**Ref No: F2025/00309**

**RE: MOD 6 IXOM Chlorine Liquefaction Plant (DA35/98-Mod-6)**

Council officers have reviewed the Modification Report prepared by Element Environment for IXOM Operations 25 August 2025 and provides the following comments below.

Figure 9 | Individual toxic irritation risk contours overall facility, before and after MOD-6 (normal and contingent modes)

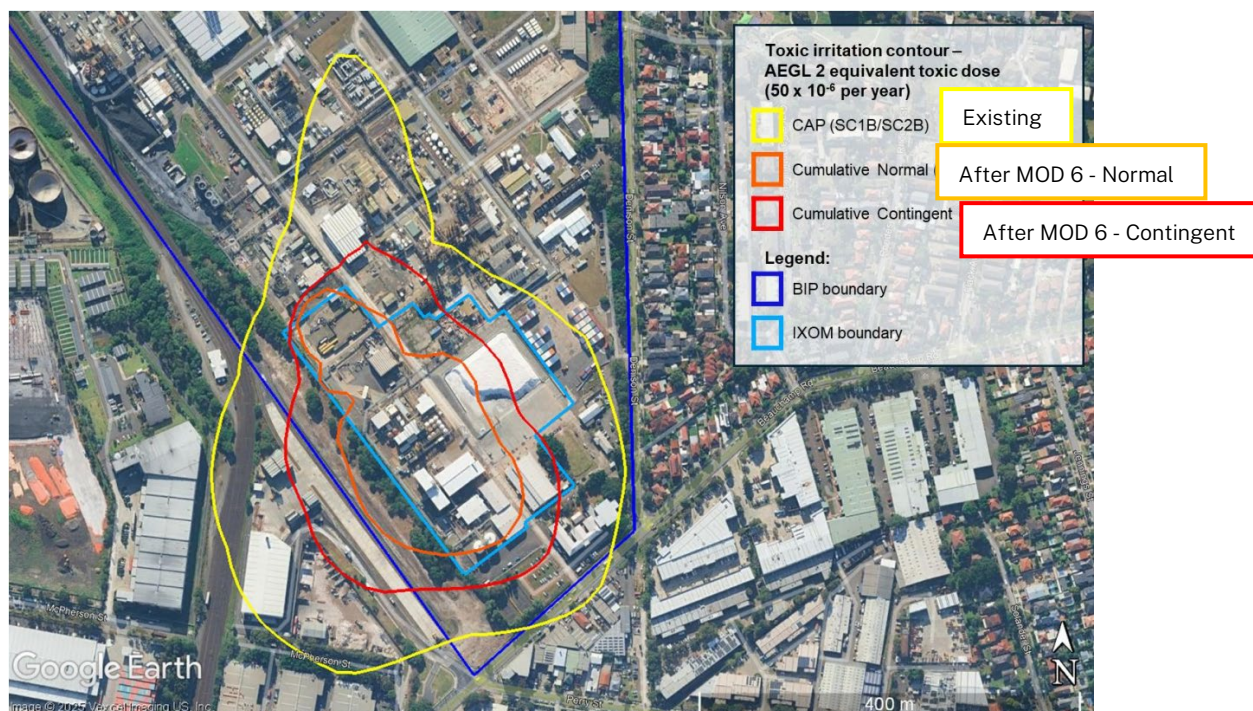
The Qualitative risk Assessment provided in Appendix D of the report includes a summary table of risks. This Table 9.1 in shows irritation injury risk extending past Ixom Boundary to the south and west. The report notes the extension of the risk contours do not reach the nearest residential areas and do not extend to non-industrial land, so the HIPAP 4 toxic irritation criterion is met.

However, this contour now extends outside of the Botany Industrial Park and reaches 38 McPherson Street Banksmeadow which is the location of the existing [Banksmeadow Recycling Yard](#). This facility is open to the general public six days a week as an independent recycling facility. This extension of the risk contours onto an existing facility with public access clearly qualifies as an offsite risk to the public. The introduction of new publicly accessible receptors within a hazard contour represents a material change in the risk profile of the development.

Under HIPAP 4, land that is publicly accessible is considered sensitive to toxic releases, as occupants are typically untrained and may be unaware of emergency procedures. The extension of a hazard contour onto such land introduces a new offsite risk to the public that was not present under the current configuration of the Chlor-Alkali Plant. This change in exposure context is significant in land use safety planning, as HIPAP 4 emphasises the need to protect vulnerable and untrained populations from hazardous incidents.
